## NE18: Natural England Comments on Cumulative Impact Assessment of Soils and Agricultural Land

**Chapter Reviewed: Volume 6.0: Environmental Statement [EN010159] Volume 2: Aspect Chapters Chapter 18: Cumulative Effects**

**Chapter Reviewed: Volume 6.0 Environmental Statement [EN010159] Volume 3: Technical Appendices Supporting ES Volume 2 Appendix 18.3 Summary of Other Developments included within the Cumulative BMV Assessment February 2025 Document Reference: EN010159/APP/6.21**

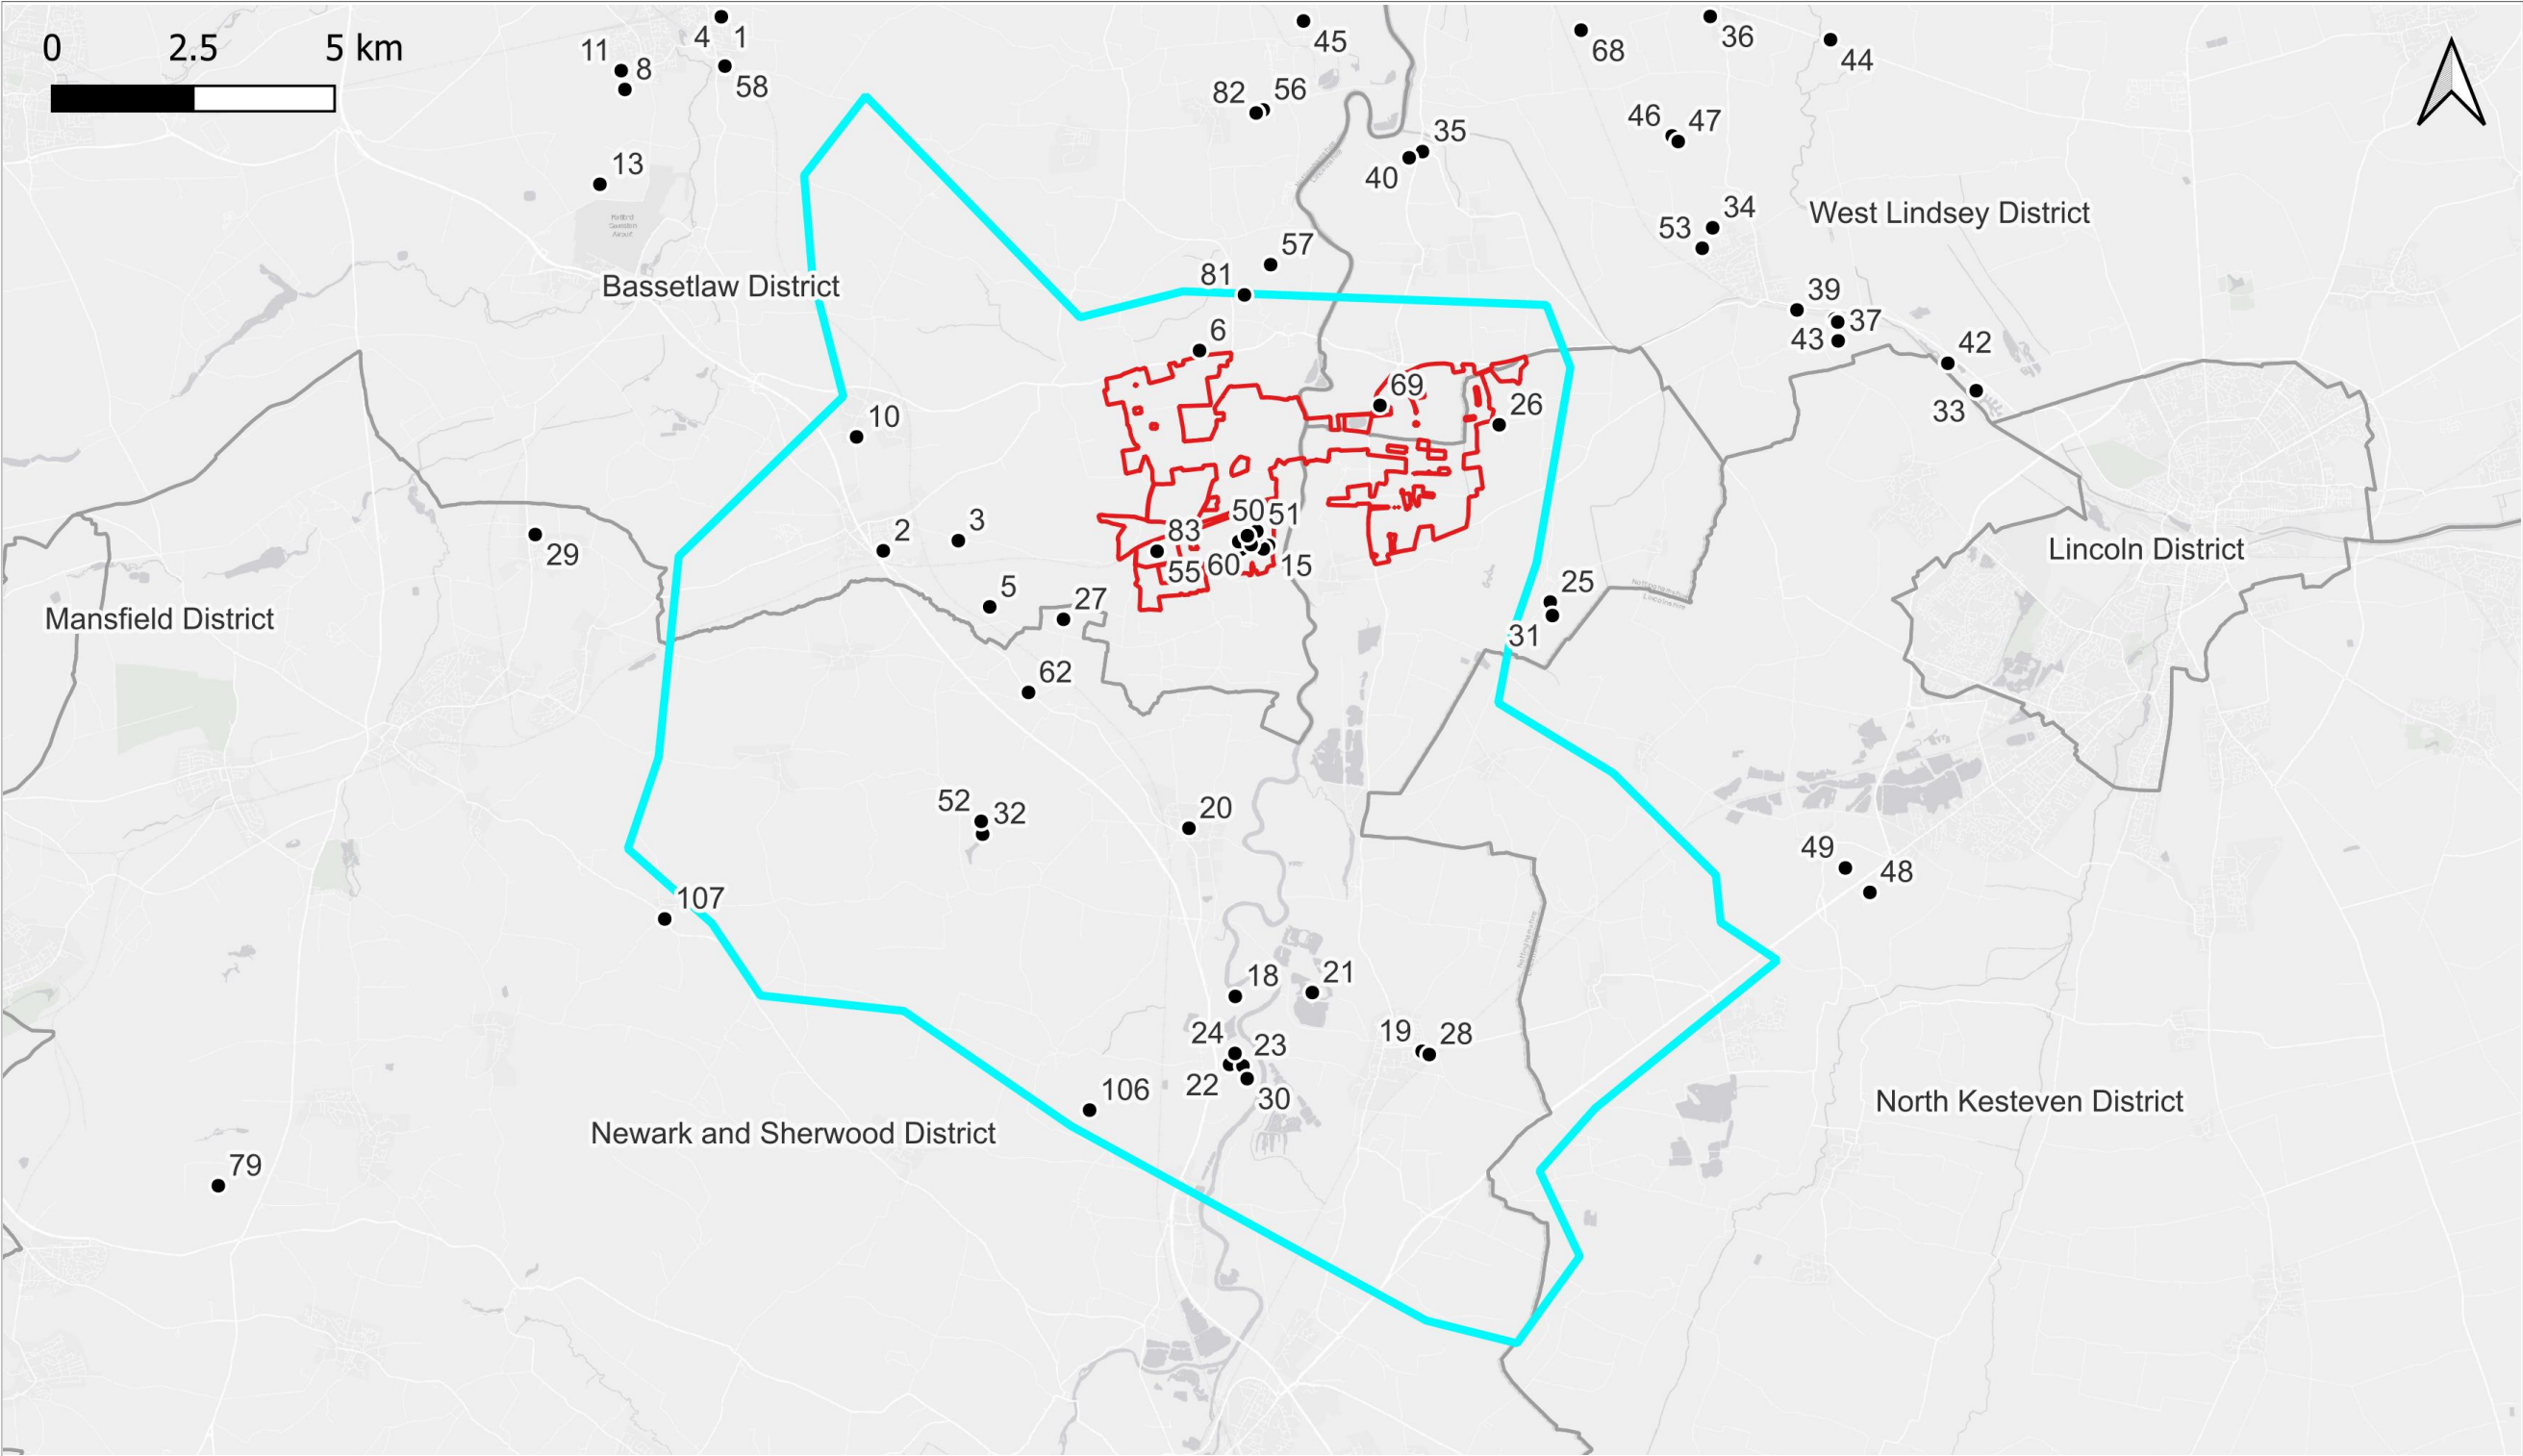
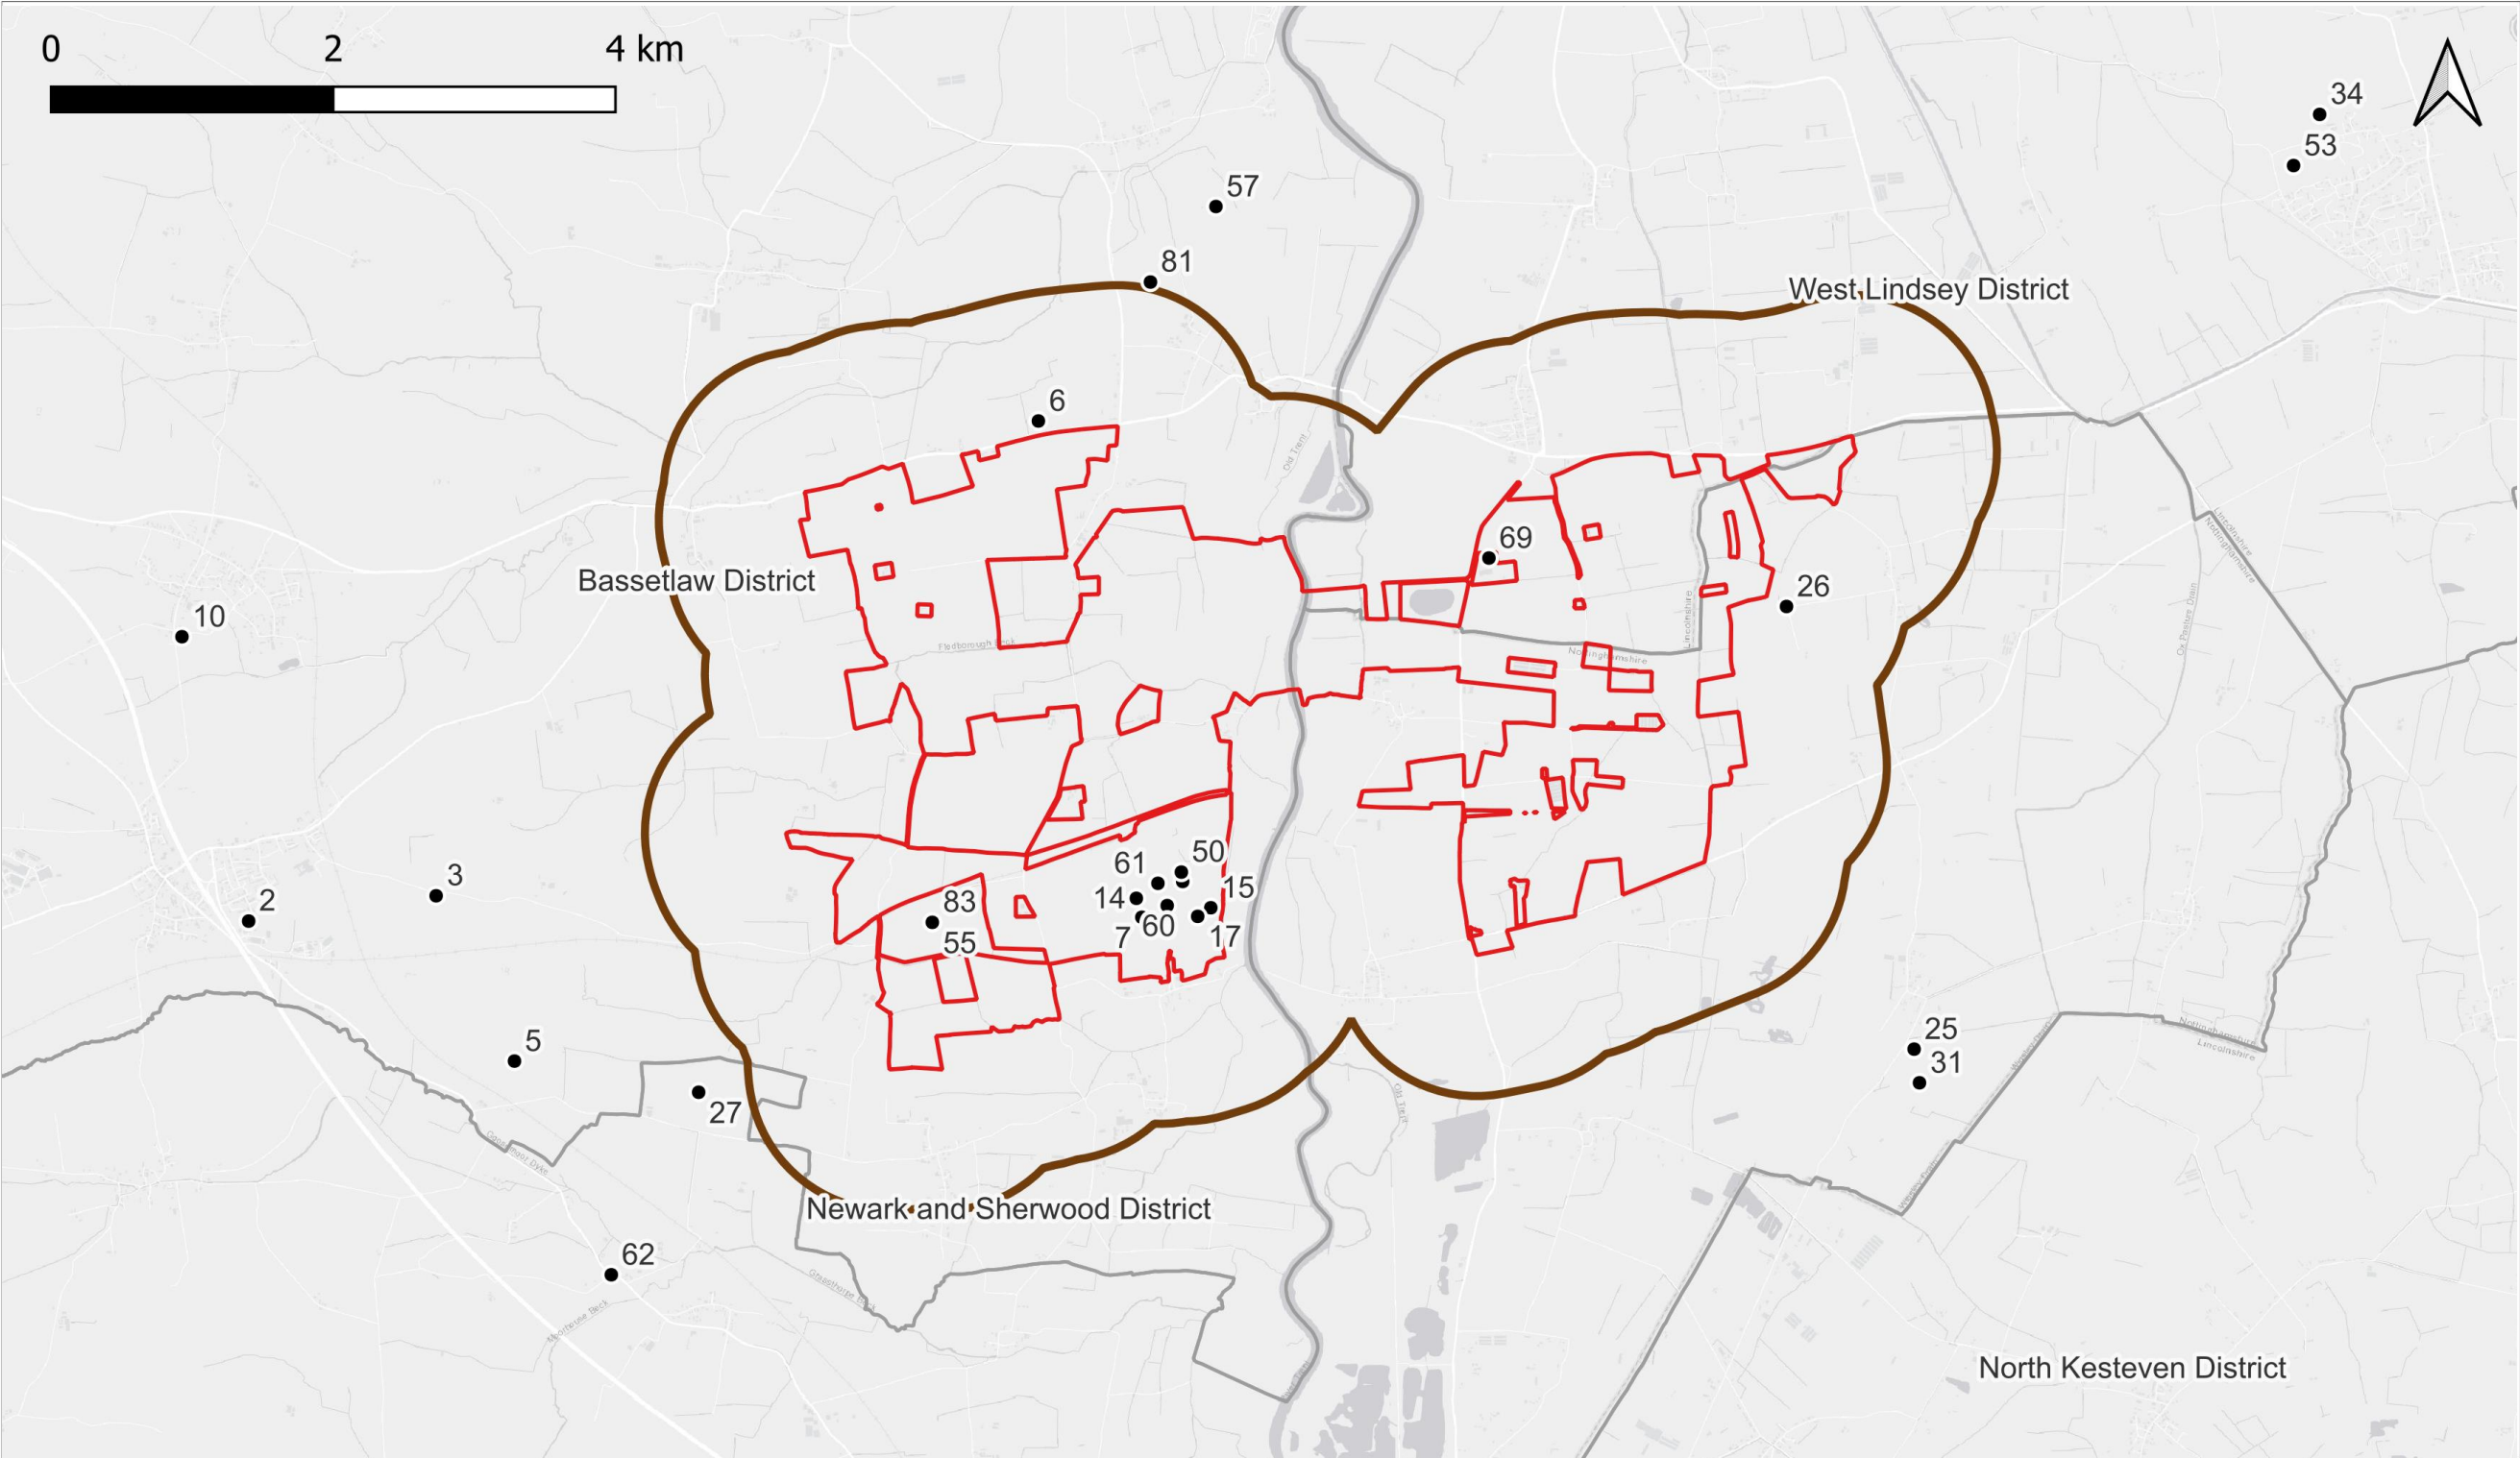
**18.3.19** Natural England are broadly satisfied with the regional Zol and the information provided within ES Volume 3, Figures 18.1 to 18.8 [EN010159/APP/6.20] for a regional cumulative assessment, however we refer the applicant back to the comment above (table 18.2)
